Engineers Comments Regarding Surface Water Drainage

Application Reference:	BR/53/26/PL	Reviewer Reference:	12/05/2026
Planning Officer:	Amber Willard	Date of Review:	ADC/EXT5/AF
Site Name:	57 Queensway Bognor Regis PO21 1QN		
Application Description:	Demolition of existing brick-built garages, removal of canopy structure, remediation of contaminated land and construction of 18 No flats over 3 storeys with pitched roofs (resubmission following BR/67/25/PL). This application is in CIL Zone 4 (Zero Rated) as flats.		
Assessment Number:	1

Standard	Assessment	Response
1. Runoff destination	Compliant	No Objection
2. Interception drainage	Insufficient	Objection
3. Extreme Rainfall and Flooding	Insufficient	Objection
4. Water Quality	Compliant	No objection subject to conditions
5. Amenity	Insufficient	No Objection
6. Biodiversity	N/A	No Objection
7. Construction, operation, maintenance, decommissioning and structural integrity	Insufficient	No objection subject to conditions

Existing and Proposed Areas
Permeable and Impermeable

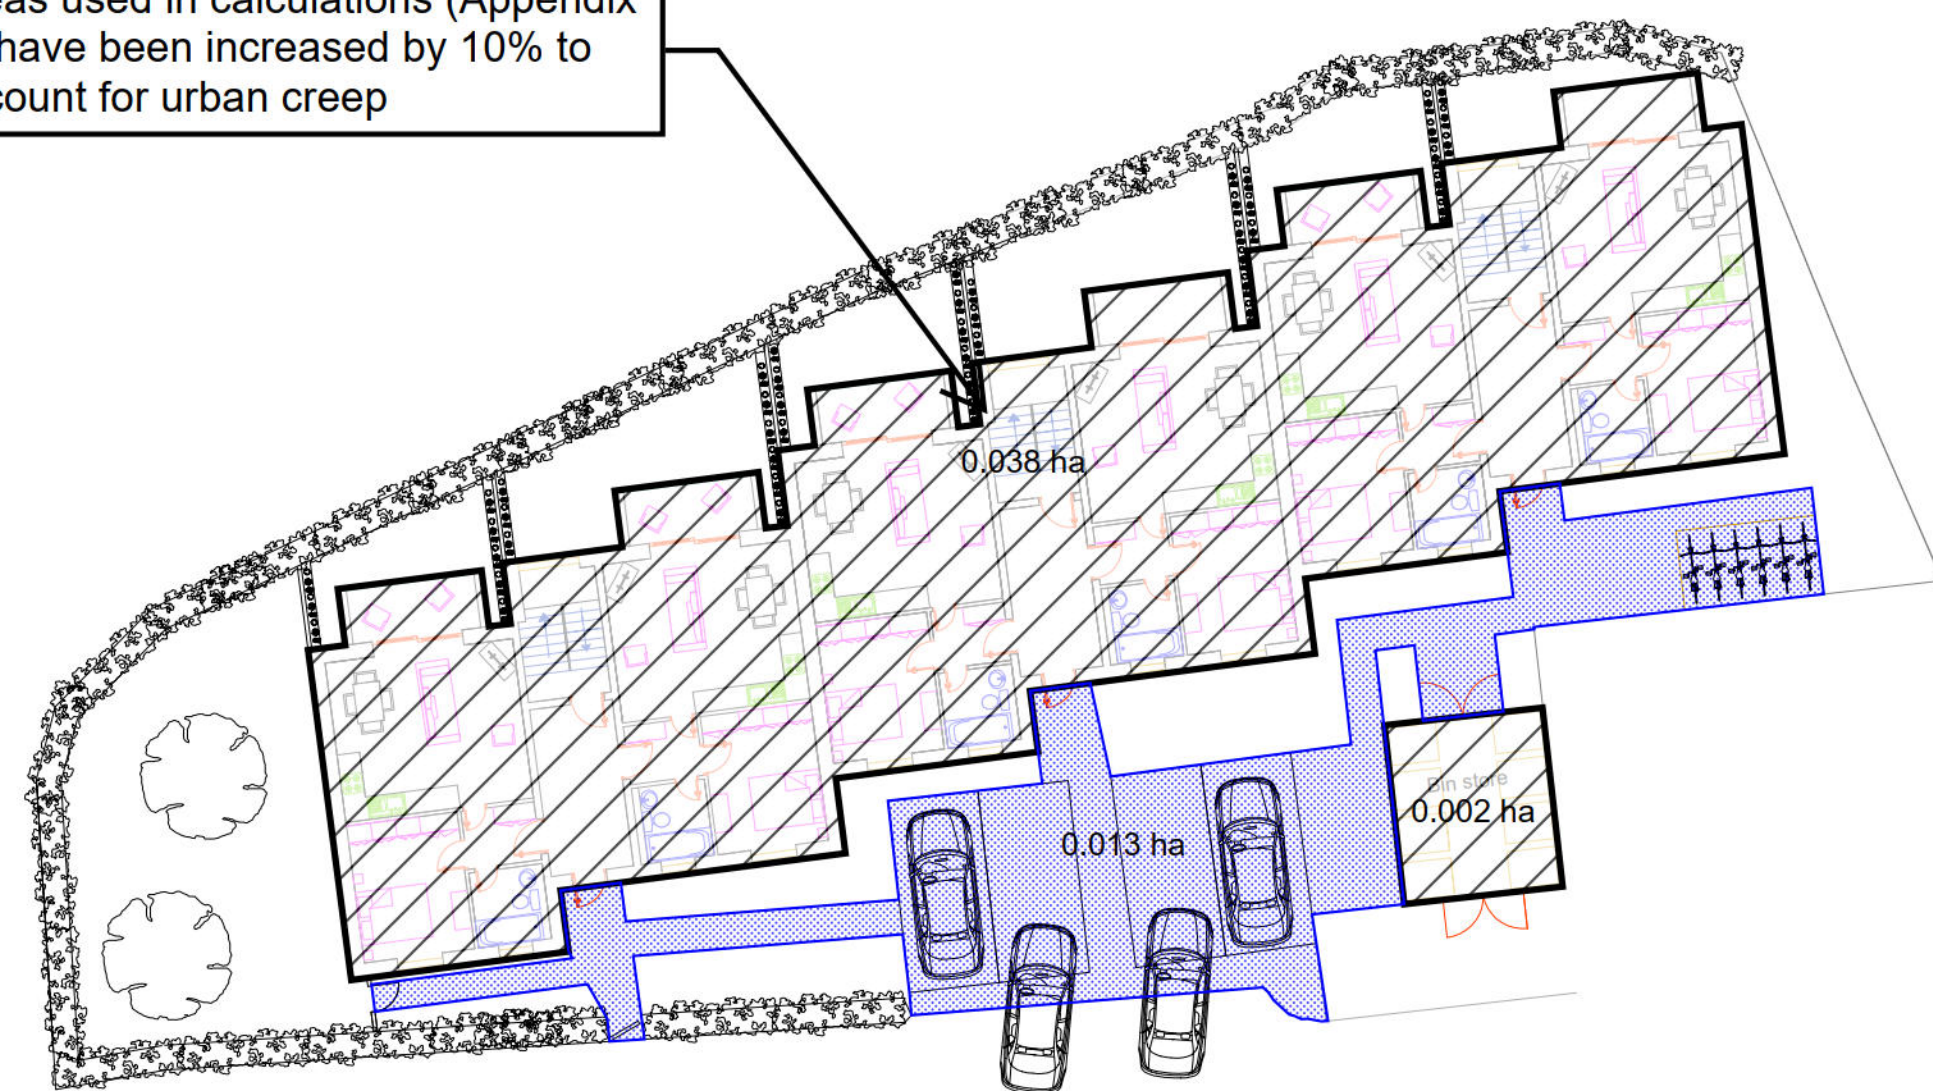
- 2.1. The parking area is permeable which allows for the self-drained area.
- 2.2. NSfS confirms that water butt do not provide interception. There are planters provided for the residential roof drainage but no calculation to confirm the development meets the requirements of the NSfS. Calculations should be provided in the Drainage Statement.
